Application No: K/22/21/HH
Site Address: South Shore House 29 Coastal Road Kingston BN16 1SJ
Description of works: Erection of additional storey to create a second floor with a rear terrace and a two storey side extension

OWPC37831

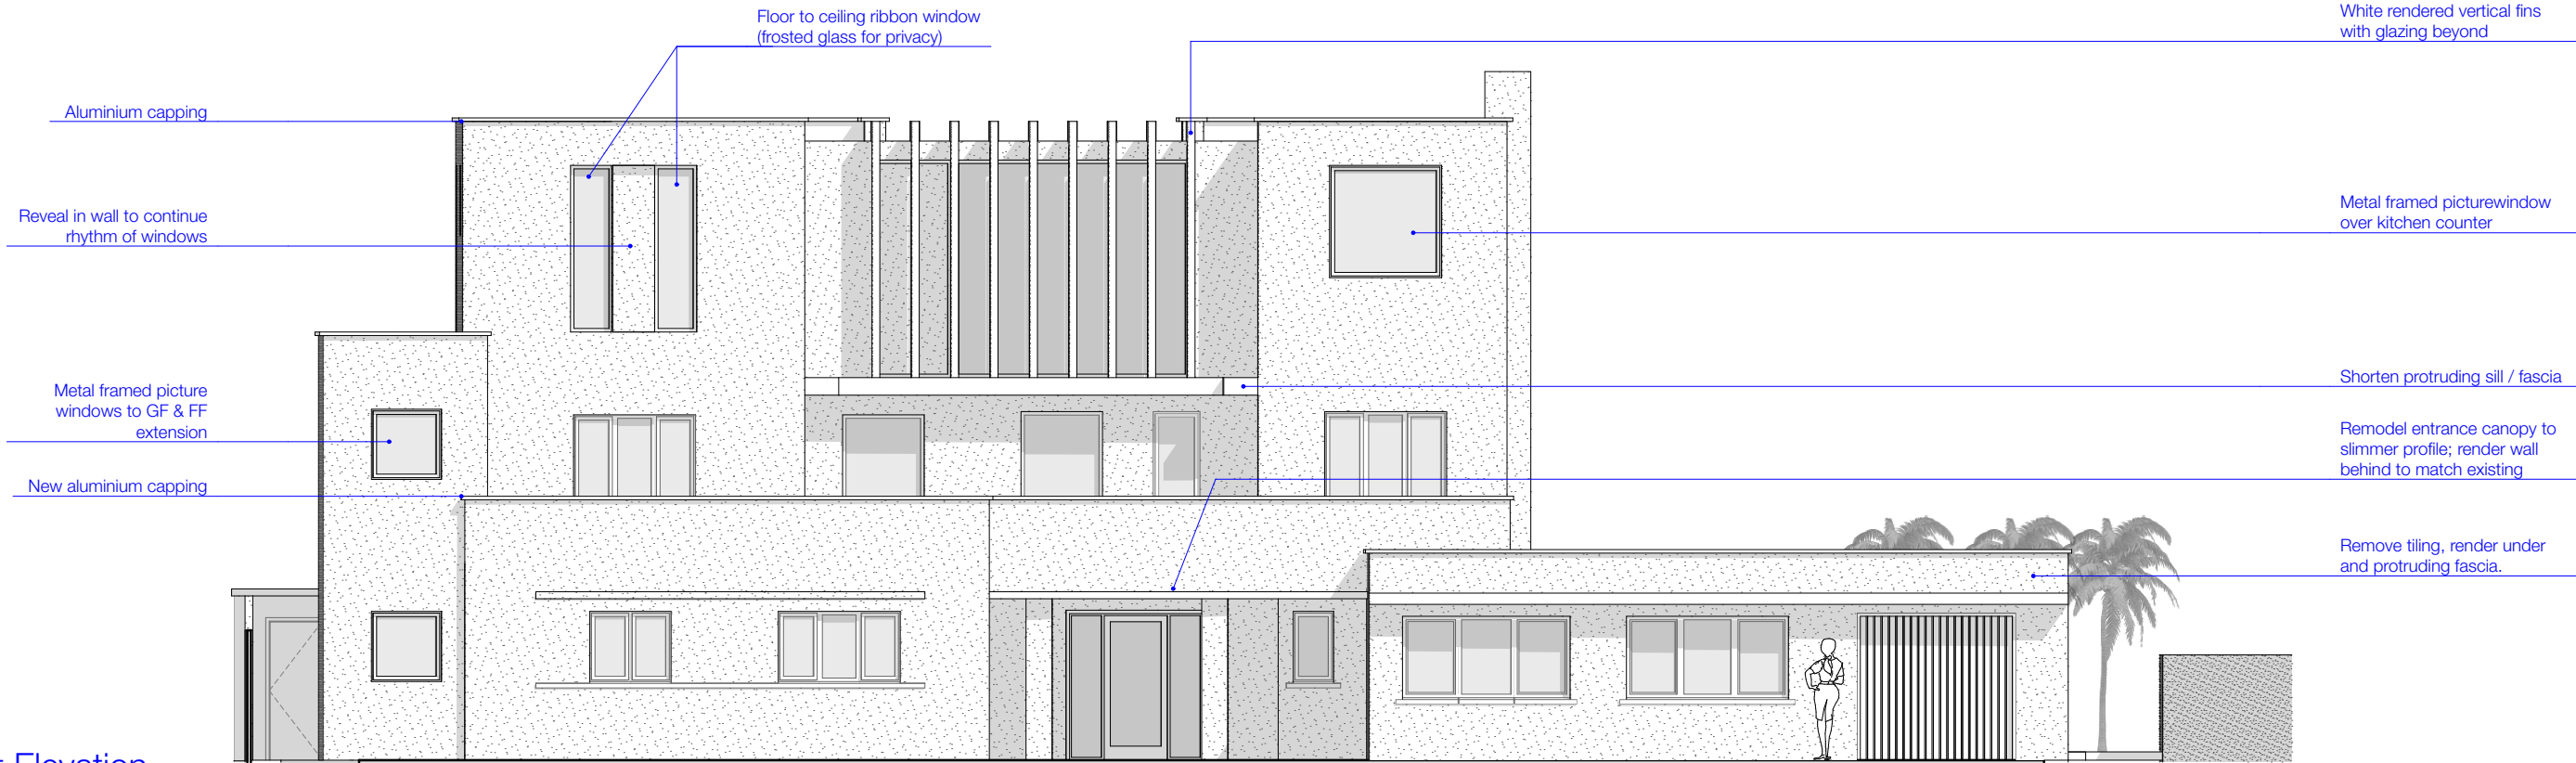
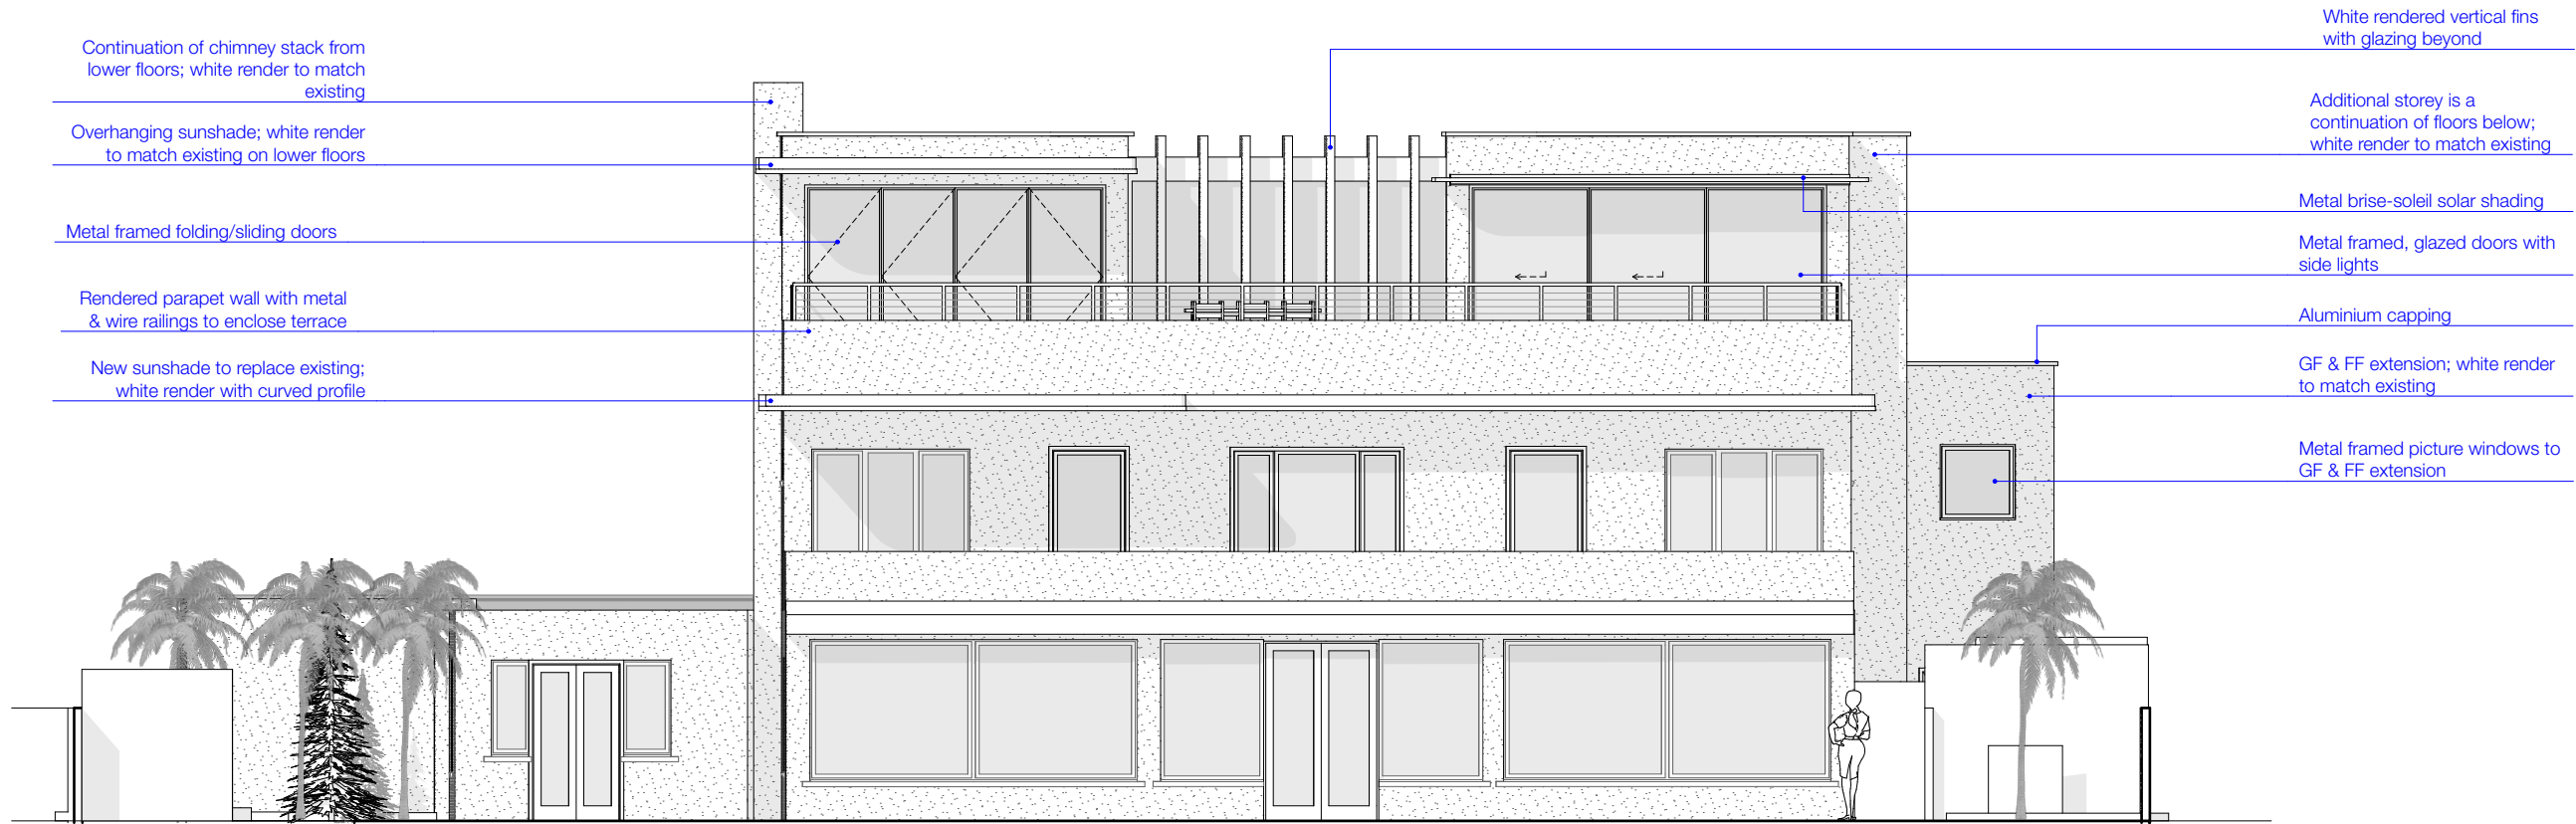
Kingston Parish Council are happy with approval subject to the Delegated Officer being sure the new terrace and windows do not overlook the neighbouring properties. The west elevation new picture frame window might well overlook the property to its West, with possible the new terrace to the rear overlooking both neighbours gardens.
